ATTACHMENT E

Date: 29 January, 2014

Memo Report

Subject: Updated Fire Protection Review of Site Plans, ICW The Forefront at Thompson's Point

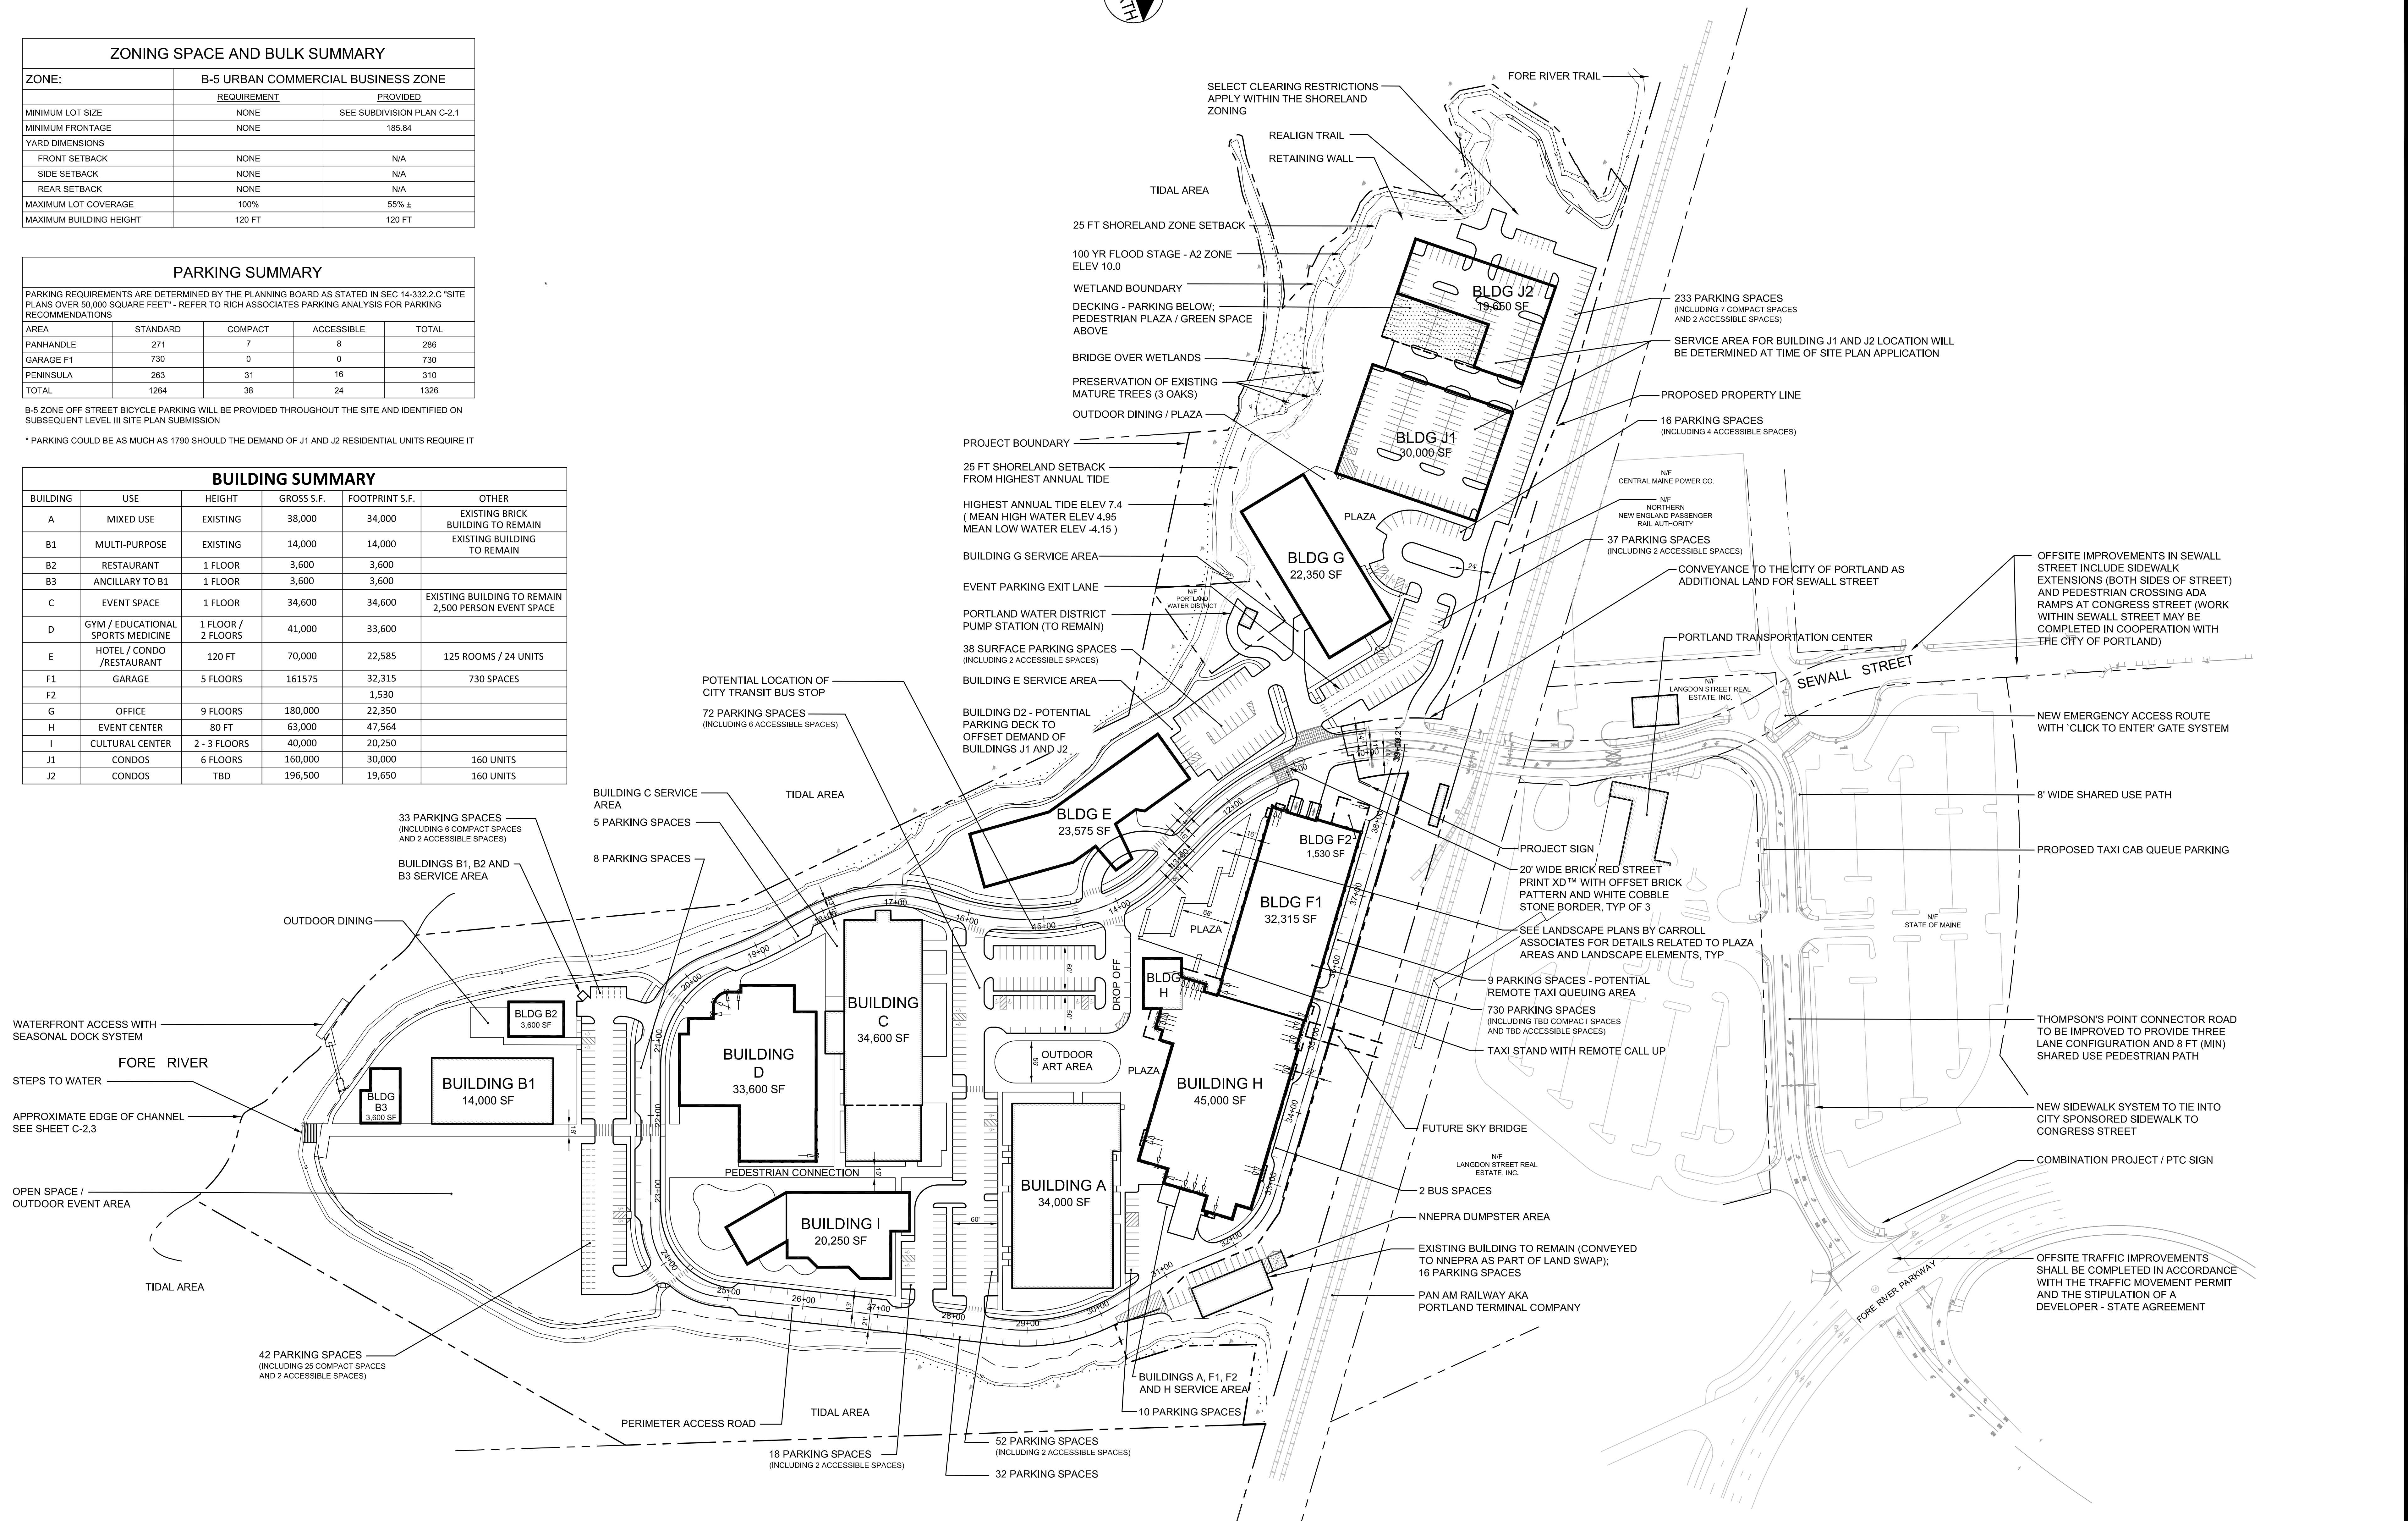
NFPA 1 also requires that any portion of a building, or the exterior walls of the building, can be no more than 450 ft from an access road when the facility is fully protected by an automatic sprinkler system; it cannot be more than 150 ft if not sprinklered. Based on a review of the site plan, it appears that this requirement will easily be met. In addition to this requirement, NFPA 1 also requires that at least one exterior door for each building is within 50 ft. of an access

roadway. The drawings provided for this review did not provide a level of detail for the individual buildings that would include locations for all available exterior doorways; albeit based on the locations of the roadways, driveways, and parking lots depicted on the Master Plan, it appears that this requirement too will easily met. However, it will still be necessary to ensure that during the design process for the individual buildings, that this requirement is accommodated.

Chapter 10 of the Portland City Ordinances has a requirement that, where available, the fire department vehicles should have access to at least two (2) sides of each building. Based on the current site plan provided, it will be possible for all buildings to be accessed from at least two sides. Both NFPA 1 and the City's regulations also include requirements for any "dead-end" access road greater than 150 ft to provide a means for fire department apparatus to turn-around. The only portion of the site access roads where this restriction applies is that section that provides access to building J2. The current Master Plan includes a general turn-around area on the west side of building J2. It will be necessary to verify that the final design for this turn-around will be compliant with the City's requirements. The City of Portland's Technical Manual includes a figure that generally depicts the recommended layout for this turn-around (Figure I-5).

Although this development is provided with only a single access point, the design of this roadway will far exceed the minimum requirements outlined by the City's Ordinances (20 ft minimum width where ladder truck may be needed). Unfortunately, the topography and the presence of a railway that isolate Thompson's Point from the remainder of the land mass restrict the ability to provide a second access point to this site. However, given the current plans for the access roadway design, having a single access is not considered to provide any significant increase in risk.

PROJECT: THE FOREFRONT AT THOMPSON'S POINT
SHEET TITLE: UTILITY PLAN - WEST
CLIENT: FOREFRONT PARTNERS I, LP

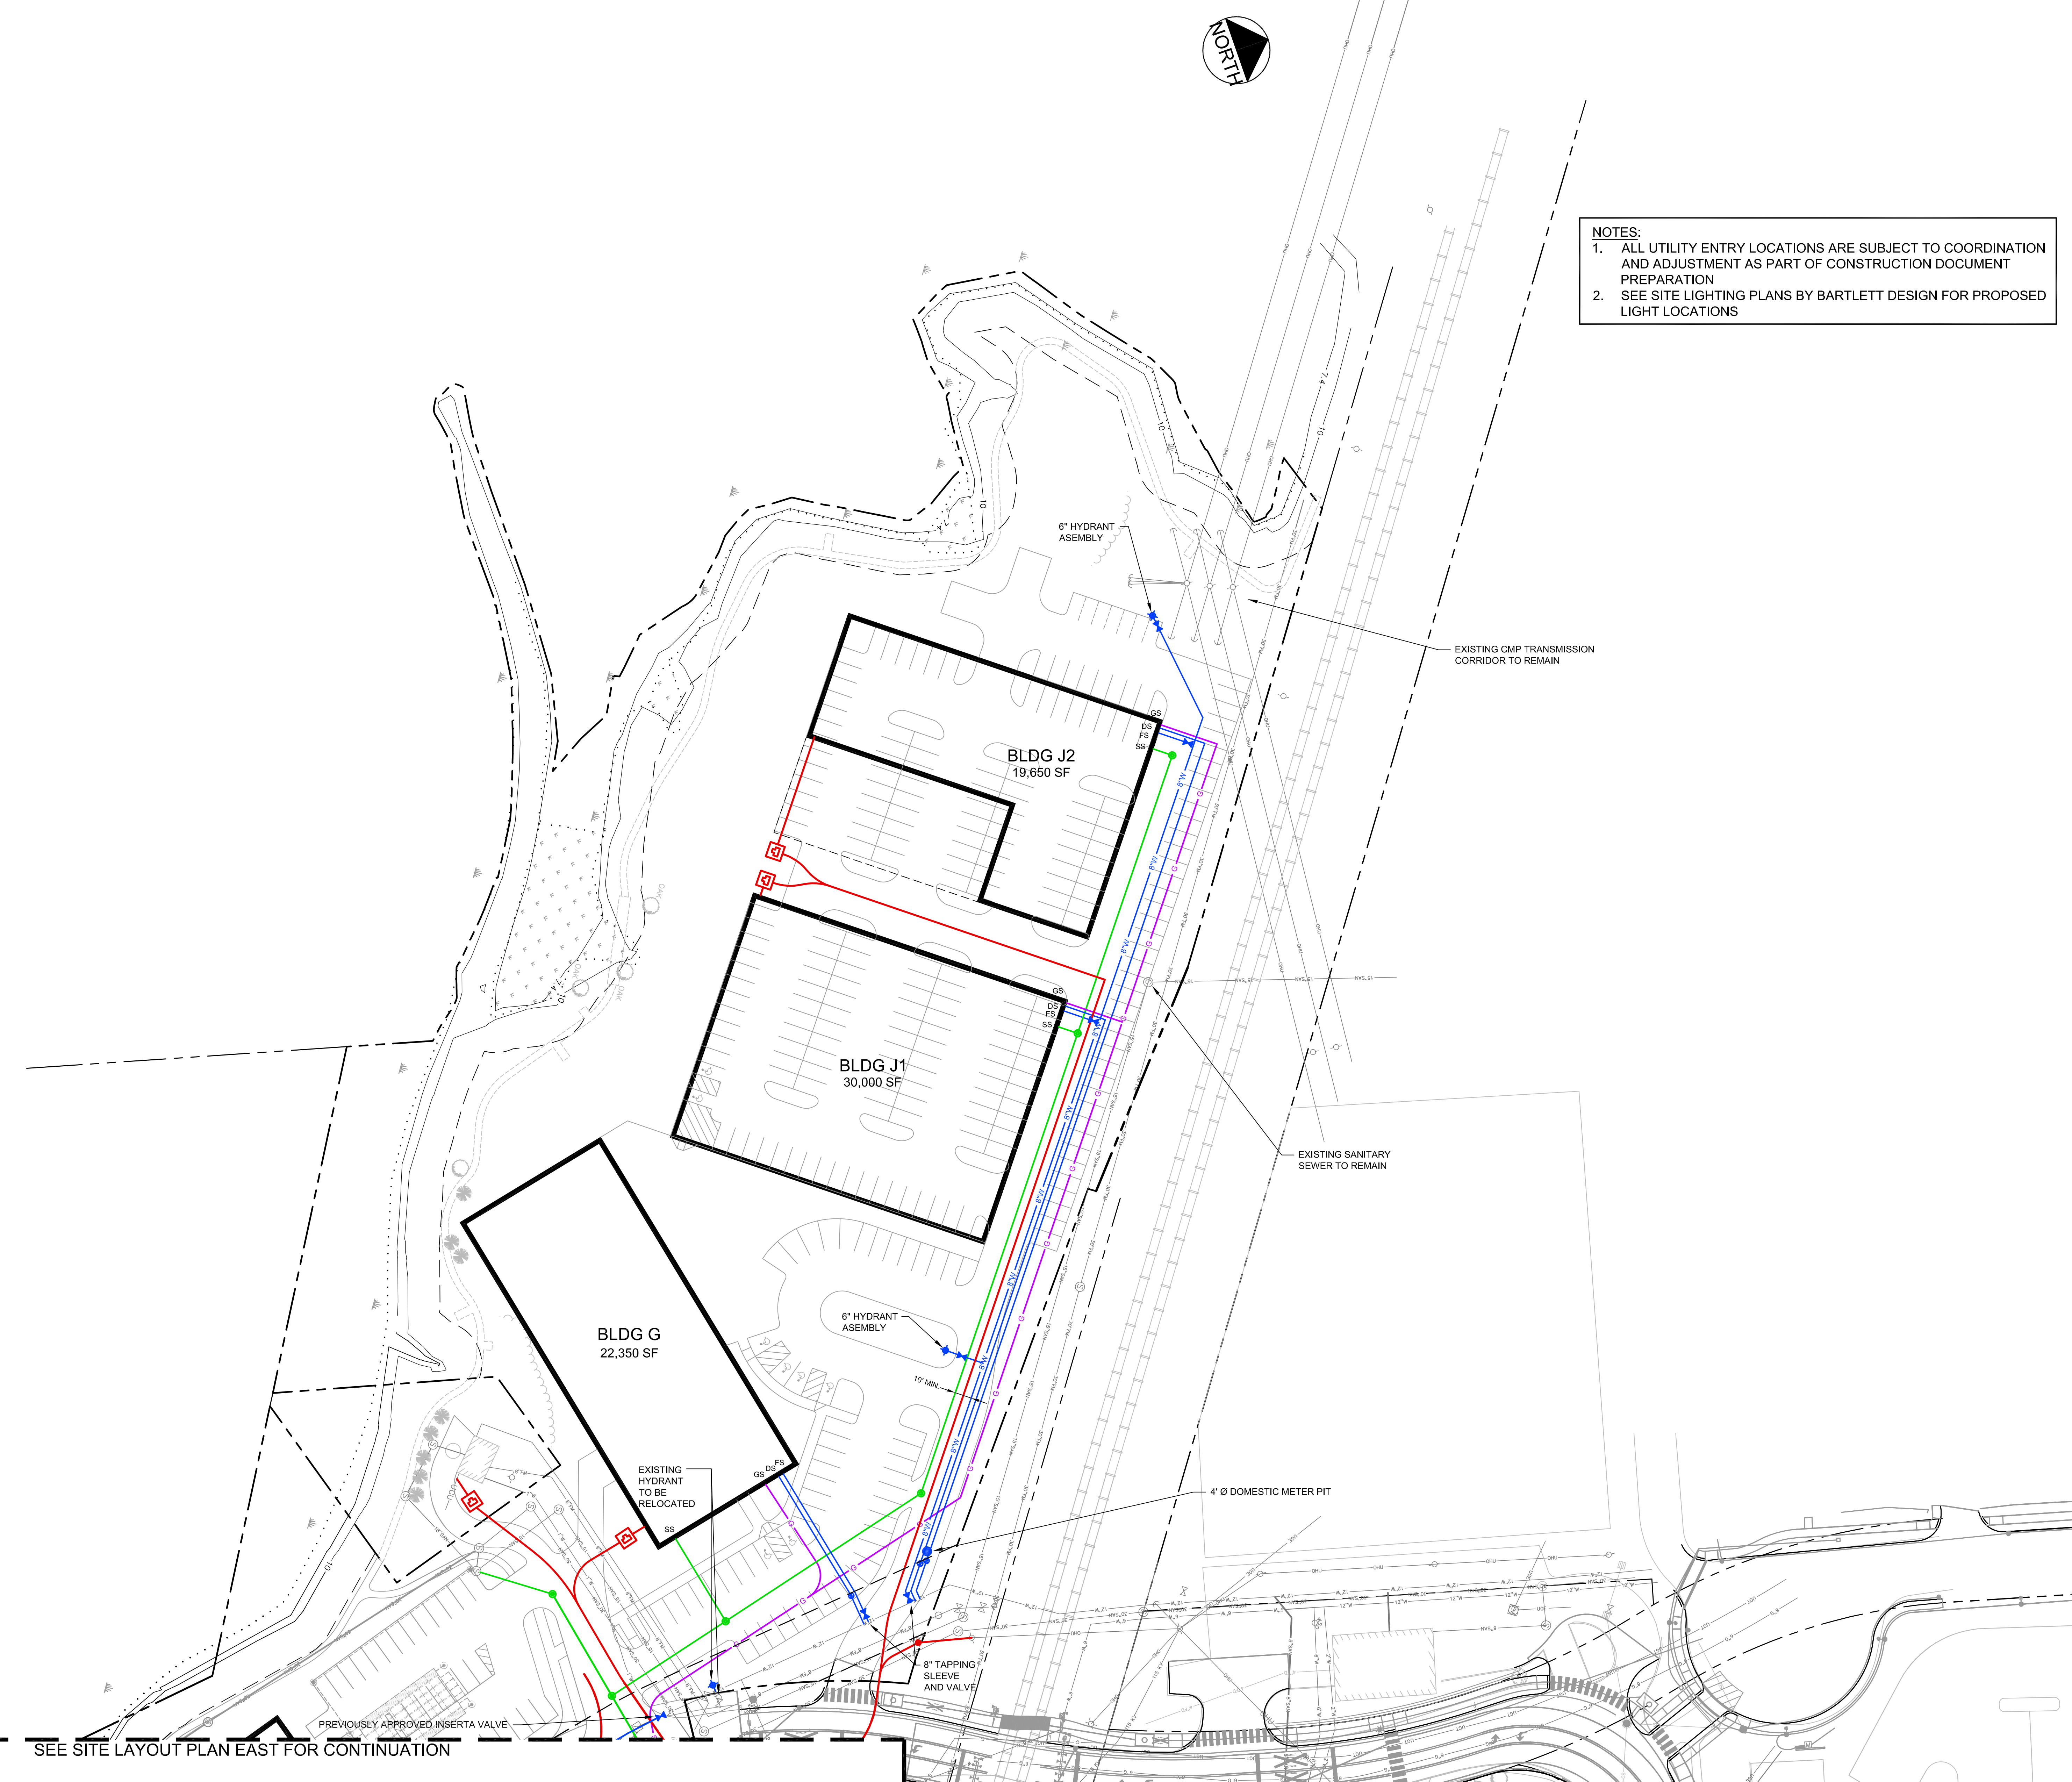
for four (4) hours would be required for each. However, given that these structures are planned to be fully sprinklered, this flow value can be reduced by 75%; to less than 1100 gpm. If building B1 is not to be provided with a fire sprinkler system, this building would then represent the worst case demand for the water supply system; 2500 gpm for two (2) hours. The hydrant flow test data previously provided by the PWD indicated that the 12" supply main serving this site can support more than 6000 gpm at the minimum of 20 psig residual pressure, which is used as that needed to be defined as "fire flow." No restriction was listed with regards to the duration for which this flow could be provided. As such, the existing water supply system for the City of Portland should have no problem acting as the primary source of fire water supply for this new development.

Based on the total fire flow demand, NFPA 1 (Annex E) would allow for a minimum spacing of either 450 ft or 500 ft between each hydrant, as measured along the fire department access road(s)¹. Ultimately, this will depend on whether or not all buildings are provided with sprinkler systems. If, for example, building B1 is not provided with a fire sprinkler system and the requisite fire flow demand is 2500 gpm, the hydrant spacing should be no more than 450 ft along the various access roads; otherwise, the 1100 gpm demand would allow for a 500 ft spacing. Although the current Master Fire Protection Plan was developed using a maximum spacing of 500 ft between hydrants, most are already shown on the plan as not being greater than 450 ft apart and where those that may be slightly more than this distance, the final hydrant locations can easily be adjusted, if/as necessary, to meet this requirement without the need for additional hydrants. Equally, for any hydrant that is considered to be located along a "dead-end" street/access roadway/etc., the distance from any point measured along that street/roadway to a hydrant should not exceed 200 ft. Using these requirements and the information provided on the Master Plan drawings, it appears that the proposed hydrant locations that are adjacent to buildings J1 and J2 (northwest corner of the development) may need to be adjusted slightly to fully comply with this requirement. However, since this can easily be accomplished within the design of the final site plan, it would not be recommended that changes to this current layout occur until the overall site plan is finalized; including building sizes and locations and a definite determination of whether any buildings will not receive a fire sprinkler system.

The Portland Fire Department Rules and Regulations include additional requirements regarding the placement of hydrants. This includes a requirement that the Fire Department Connection(s) (FDCs) for each building must be within 100 ft of a hydrant. Additionally, NFPA 24 (along with the City) has a requirement that no hydrant should be located within 40 ft of a structure. Since the level of detail for the individual buildings provided at this point in the design process is such that it is not known where the FDCs will be located for each building, it cannot be determined as part of this review whether or not this requirement will be met. However, in other recent projects, the City has agreed to "waive" the requirement for a hydrant to be within 100 ft of the FDC; primarily since the genesis of this requirement isn't fully understood and this is not a "typical" requirement for most other municipal Fire Departments. It is understood that the hydrant that is currently depicted as being located adjacent to building H is within 40 ft of this structure. However, as discussed in a number of teleconferences between FST and FRM, it is recommended that this current location be retained. It is understood that the proximity of the access road along these buildings is so close to the property line that a hydrant cannot be installed on the other side of the access road. However, installation of the hydrant at this location has a greater advantage in meeting the overall water supply requirements for the site than the disadvantage of its close proximity to building H. Its removal would then result in the inability to meet the maximum spacing between hydrants. Given that if a fire is within building H, other hydrants are readily available to support firefighting operations, it is considered that the plan to install this hydrant in this location represents the best option for providing the overall site with adequate fire protection. Where it may be in the best interests of the overall firefighting plan for a building/site, the codes do allow for the Authority Having Jurisdiction (AHJ) to accept hydrant locations within the 40-foot limit.
